Justinian House Redevelopment

BCA Assessment Report

REPORT 2007/362 R1.1

October 2007

1:200 @ A1
SDATES
0 2 4 6 8 10 12
DA 1001 A
drawing no. revision

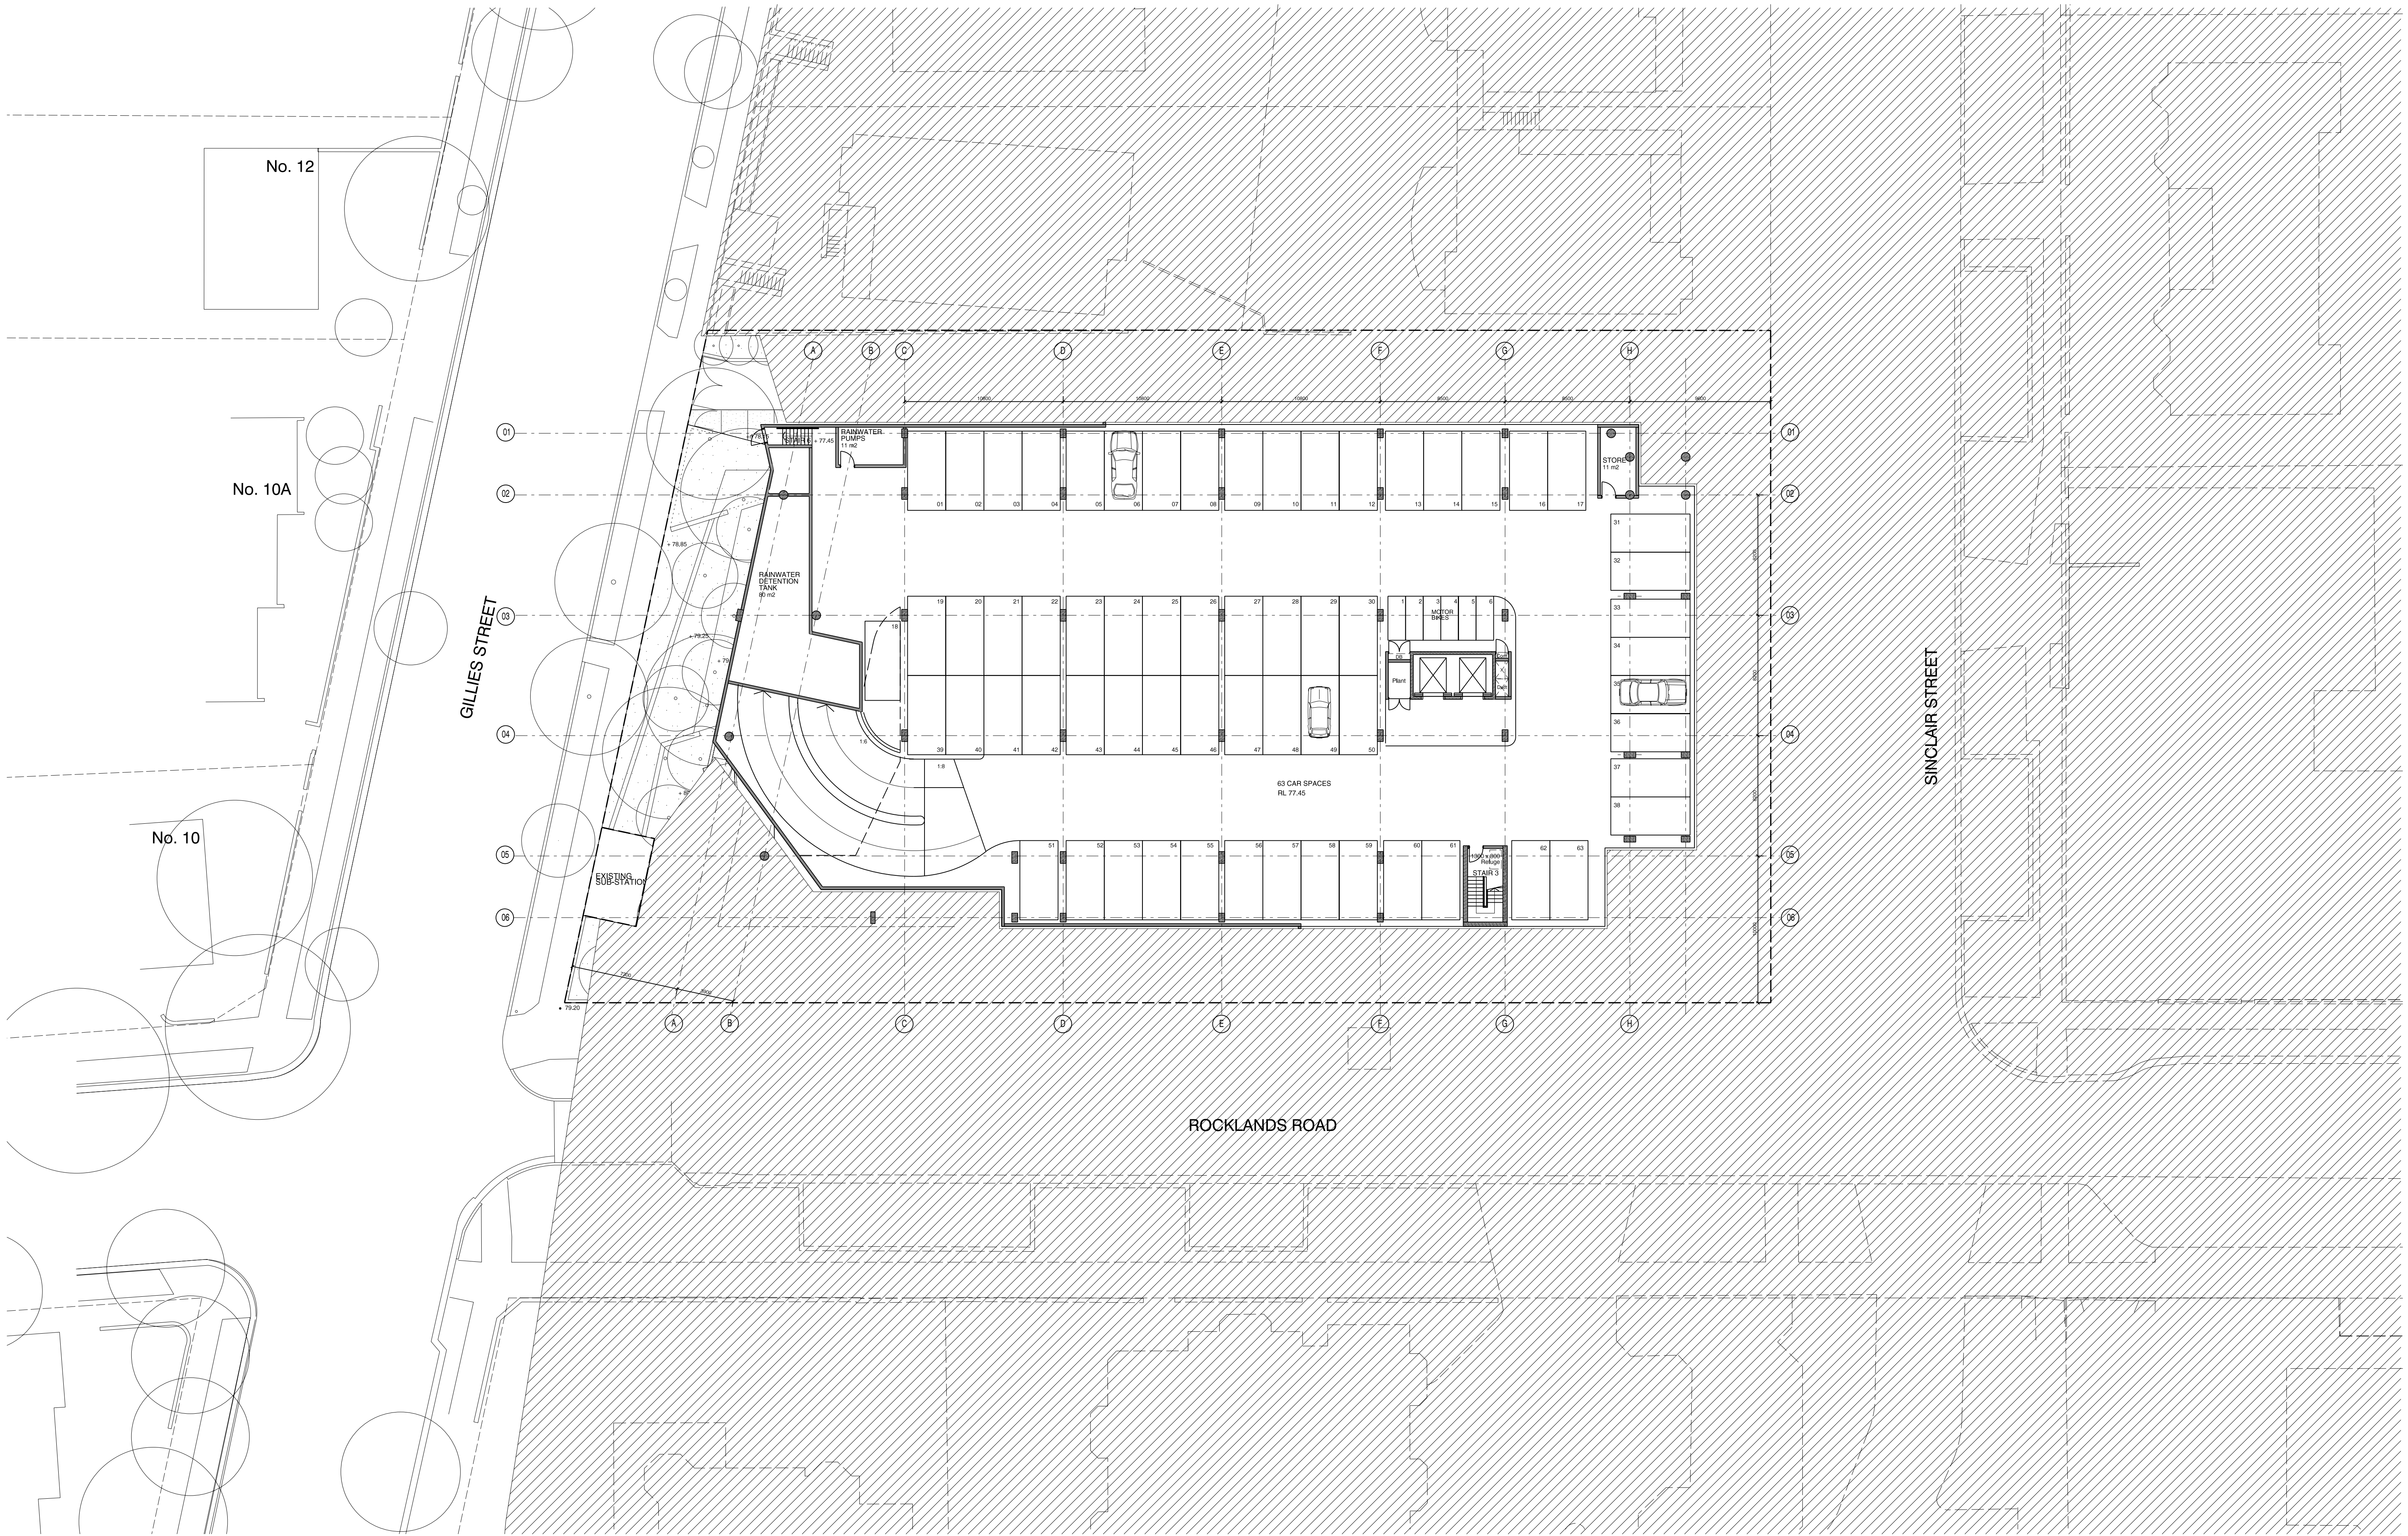
4.	Distance between alternative exits	D1.5	<p>Travel distance between alternative exits exceeds the maximum 60m permitted as follows;</p> <ul style="list-style-type: none"> • Approximately 68m between exits in basement 2 when measured through the point of choice. 	DP4	To be addressed by Fire Safety Engineer.
